LOCATION 914 Baxter Blvd CBL 166 D003001

TO: Inspections
FROM: Jay Reynolds, Development Review Coordinator
DATE: June 3, 2002
RE: C. of O. for # 916-918 Baxter Blvd.
Lead CBL (166-D-003) ID# (2001-0149)

Subject: 916-918 Baxter Boulevard Duplex
(ID#2001-0149)(CBL#166-D-003)

SITE PLAN

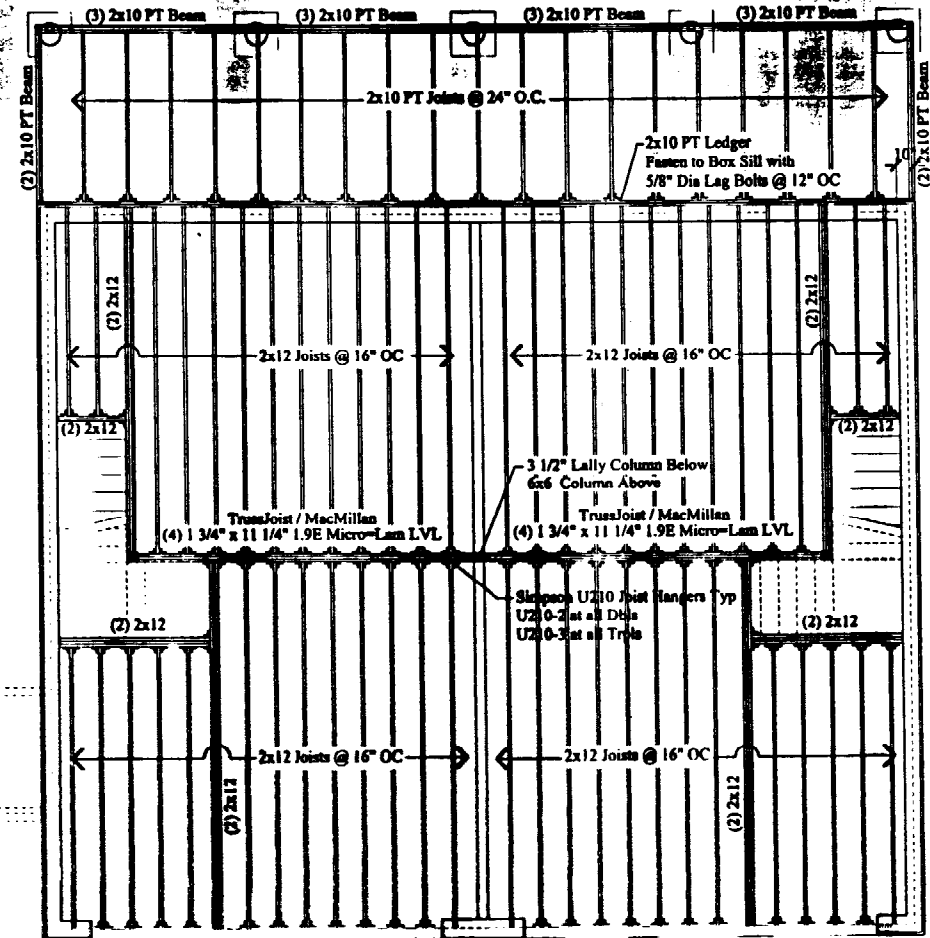
1. Final Grading Incomplete.
*Compliance letter sent to owner/applicant on January 22, 2002, regarding grading and drainage.
1. Loam and Seed Incomplete.
1. Landscaping Incomplete.

On November 30, 2001, I inspected the development of your site, and identified an item of concern. It appears that the grading of your site on the westerly side of your lot has been done in a manner that may increase runoff onto the neighboring property. Because of the proximity of the neighboring garage/house to the property line, the potential of creating a water problem may exist.

As part of my review and approval, I had specifically conditioned that the "Applicant/contractor shall perform grading along westerly property line so that no ponding of water occurs and that drainage does not flow onto the neighboring property" (Condition #1 under DRC Approval).

Due to the time of year, it is not possible to complete these items. I would estimate that these items could be completed by **June 30, 2002**. Once these items are addressed and re-inspected, then a permanent Certificate of Occupancy can be issued.

Due to the time of year, this item cannot be corrected at this time. This item must be resolved prior to obtaining your certificate of occupancy.
